**KIRKLEES METROPOLITAN COUNCIL
INVESTMENT & REGENERATION SERVICE**

DELEGATED DECISION TO DETERMINE PLANNING APPLICATIONS

Reference No:	2025/62/90655/E
Site Address:	The Priory, Whitechapel Road, Cleckheaton, BD19 6HR
Description:	Demolition of existing pub and erection of a new two storey building comprising 8 self-contained supported living flats with ancillary staff facilities, single storey summer house and other associated works
Recommending Officer:	Kerri Simpson

Officer Report – 2025/90655

SECTION LOCATION
1:1000

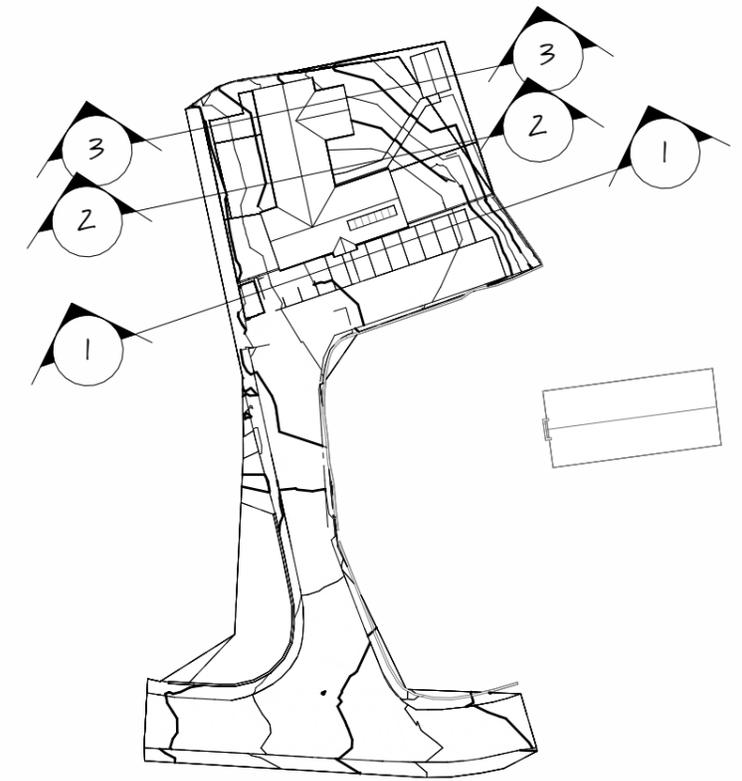
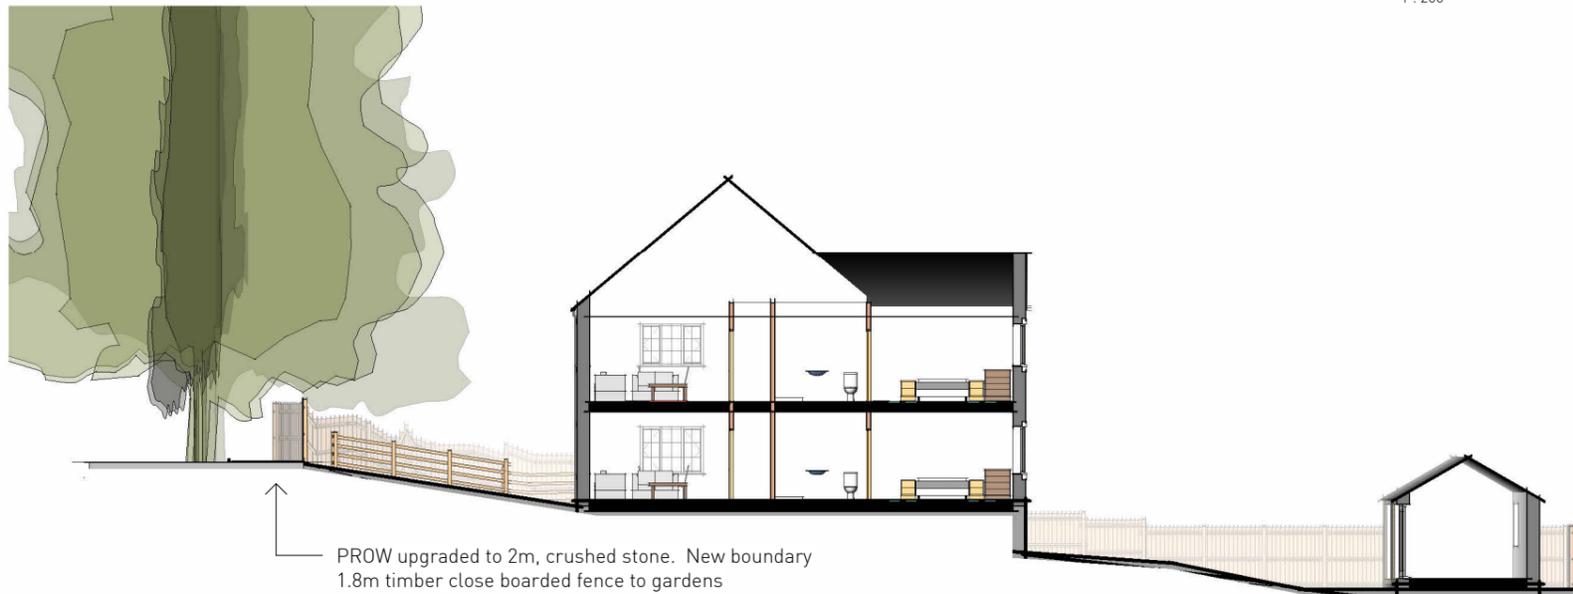
12th May 2025 – The Council's Public Right of Way (PROW) Team raised concerns that the initially submitted documents did not include the public footpath (PROW) "Spenborough 24" which runs adjacent to the existing building. The PROW Team requested the inclusion of the PROW in submitted drawings, including details of the boundary treatment, width of path to be provided, surfacing and how the path is to be maintained during construction. The applicant submitted the following drawings for consideration:

KC PROW Team (08/05/2025) - Objection. Public Footpath Spenborough 24 runs adjacent to the site. KC PROW objects due to lack of reference to the footpath in this submission and in sufficient detail on its protection, such as boundary treatments, width, surfacing and maintenance. A temporary closure may be needed during demolition. If approved, a condition should secure that the footpath remains unobstructed throughout the works.

KC PROW Team (20/05/2025) - No objection. Amended plans received, as long as the development is set back from the boundary far enough to fit a 2m wide path, and this could be conditioned, then the PROW Team would remove its objection. There is no objection to the use of crushed stone for the path. PROW would authorise any temporary closure for demolition, however we could not allow this for the length of the development.

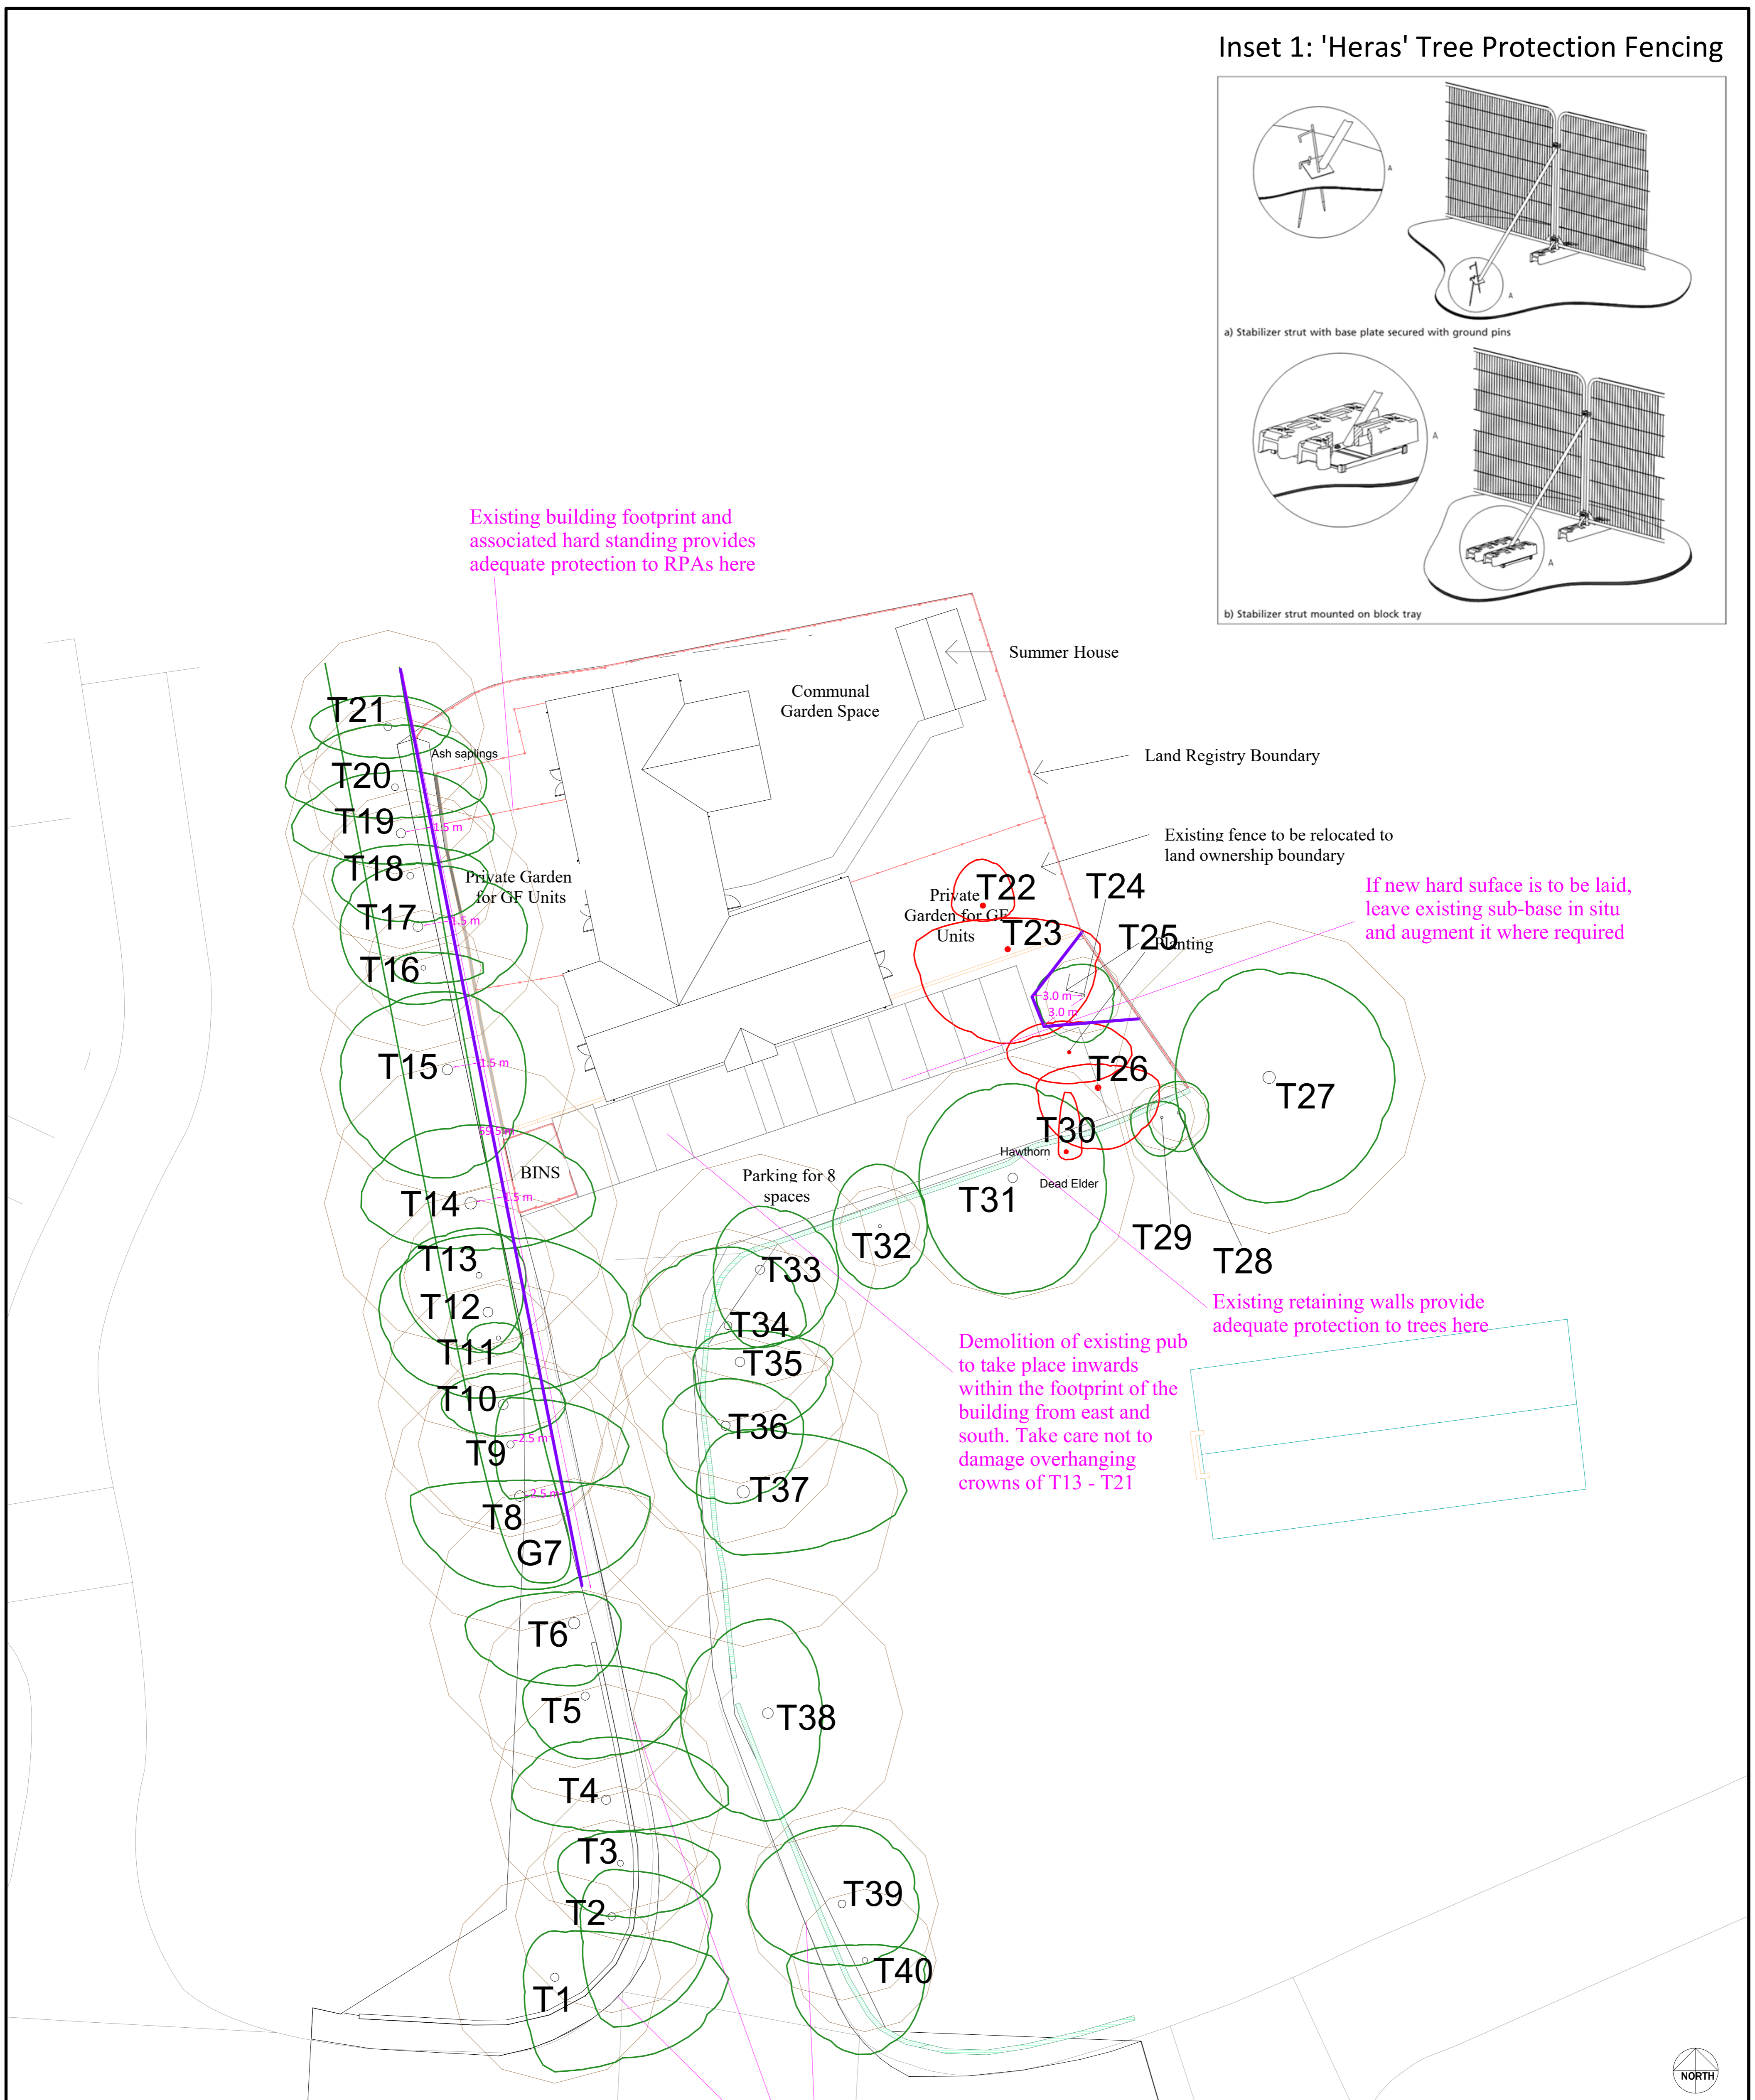
4th June 2025 – The Council's Tree Officer sought clarity as to whether a T24 (Hawthorne) tree was to be retained or removed. The applicant submitted a revised Arboricultural Impact Assessment which confirms the tree is to be retained.

KC Tree Officer - No objection, several trees within and adjacent to the site could be affected by the development including protected trees on the western boundary (TPO ref 01/10). The submitted Arboricultural Method Statement (AMS) proposes removal of three low value trees (T22, T23, T26) to facilitate development, and two further trees (T25, T30) due to safety concerns. The retention of T24 is unclear, as the AMS shows it for retention but also references removal. Clarification is required. Protective measures set out in the AMS are acceptable and must be followed throughout the development. No objection is raised from an arboricultural perspective.
